# Rezoning Transportation Analysis

Petition Number: 2023-069

| Date     | Description        |
|----------|--------------------|
| 10-26-23 | First Review (NK)  |
| 11-27-23 | Second Review (NK) |

**RZP-2023-069
 REZONING**

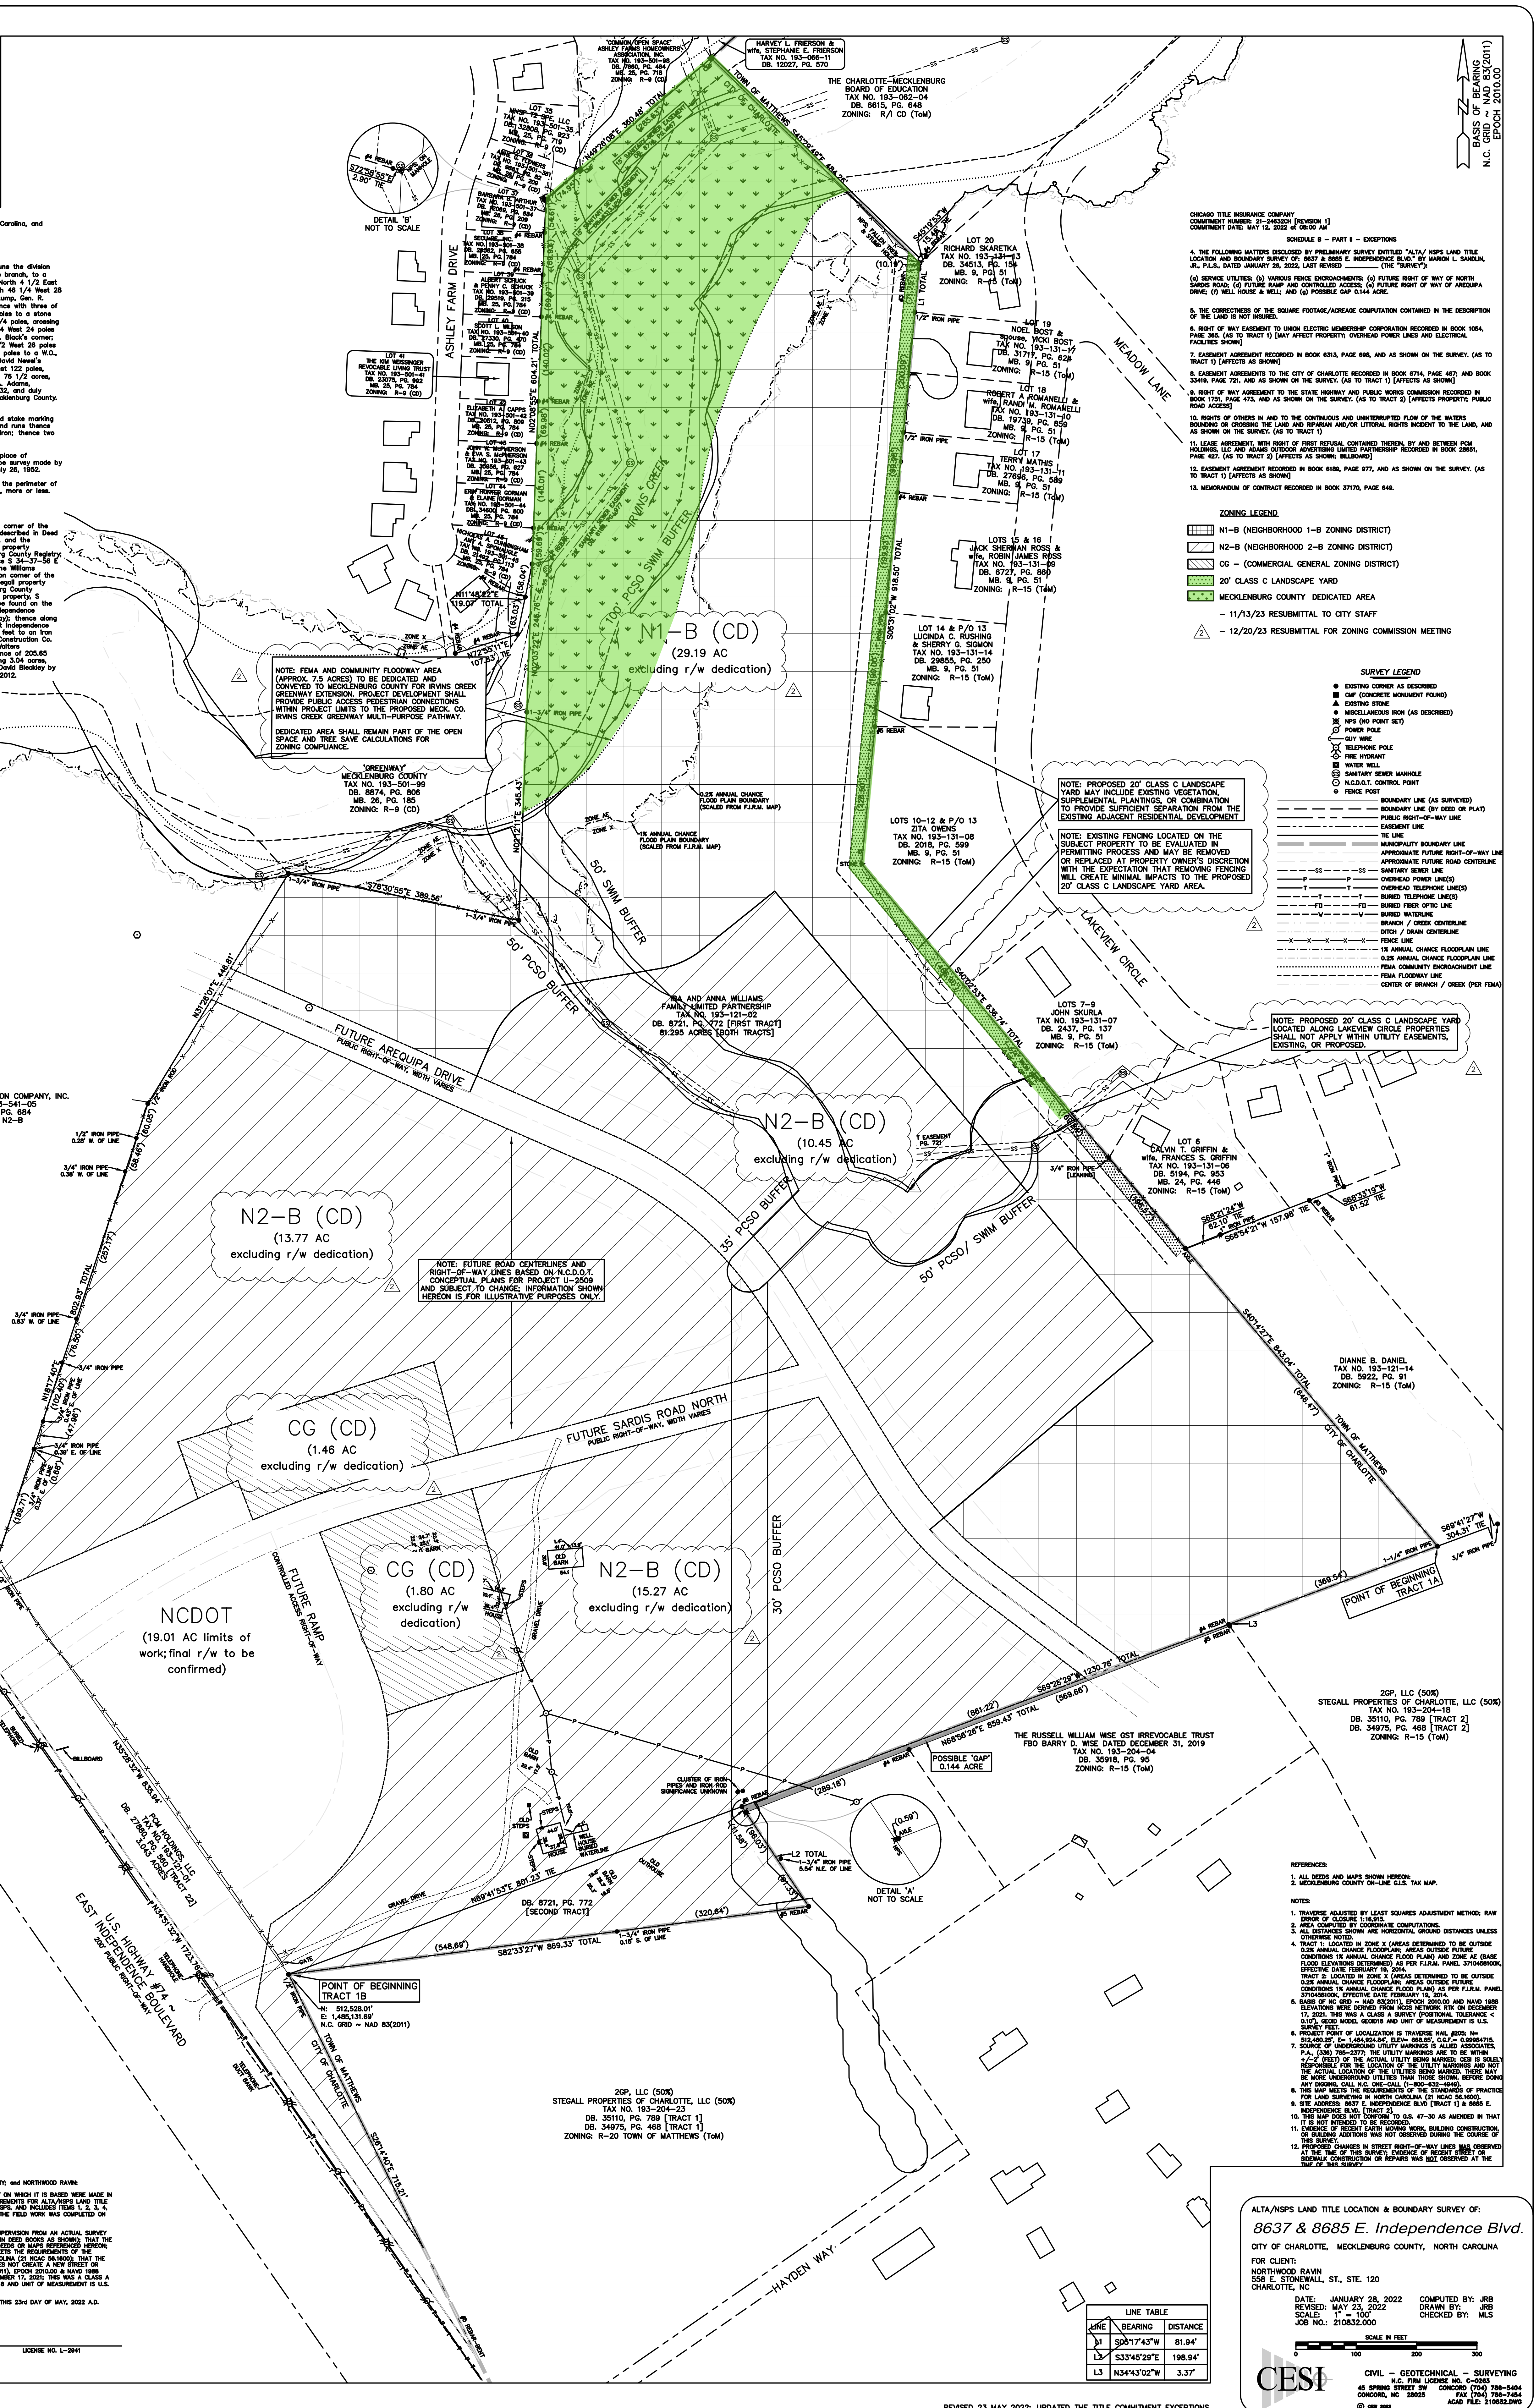
**1. ~~Curbline:~~**

a. ~~Independence Boulevard:~~ The future location of curb and gutter is in its existing location.

~~Independence Boulevard is a limited access street according to the streets map and does not require streetscape modifications.~~

~~Label and dimension the curb and gutter from the centerline for each road on the site plan.~~

**3. ~~Revise site plan and conditional note(s) to commit to dedicate 54' right-of-way from the road centerline for Sardis Road North. The site plan shall label and dimension the right-of-way from the road centerline.~~**

~~Revise site plan and conditional note(s) to commit to dedicate 40' right-of-way from the road centerline for Arequipa Drive. The site plan shall label and dimension the right-of-way from the road centerline.~~

- ~~4. Revise site plan and conditional note(s) to commit to construct bicycle facilities by locating the curb and gutter 38' from the center line along Sardis Road North.~~

- ~~6. Revise site plan to include cross sections, road classification, and width for proposed public roads.~~
- ~~7. Revise site plan to commit to extending Sardis Road North to edge of property line.~~

- ~~8. Revise site plan and conditional note(s) to commit to installing 6' sidewalk and an 8' planting strip along Sardis Road North and Arequipa Drive.~~

- ~~9. Revise site plan to show any other proposed private streets and provide location of all future buildings.~~
- ~~10. Additional comments may be issued following coordination with NCDOT and other departments.~~
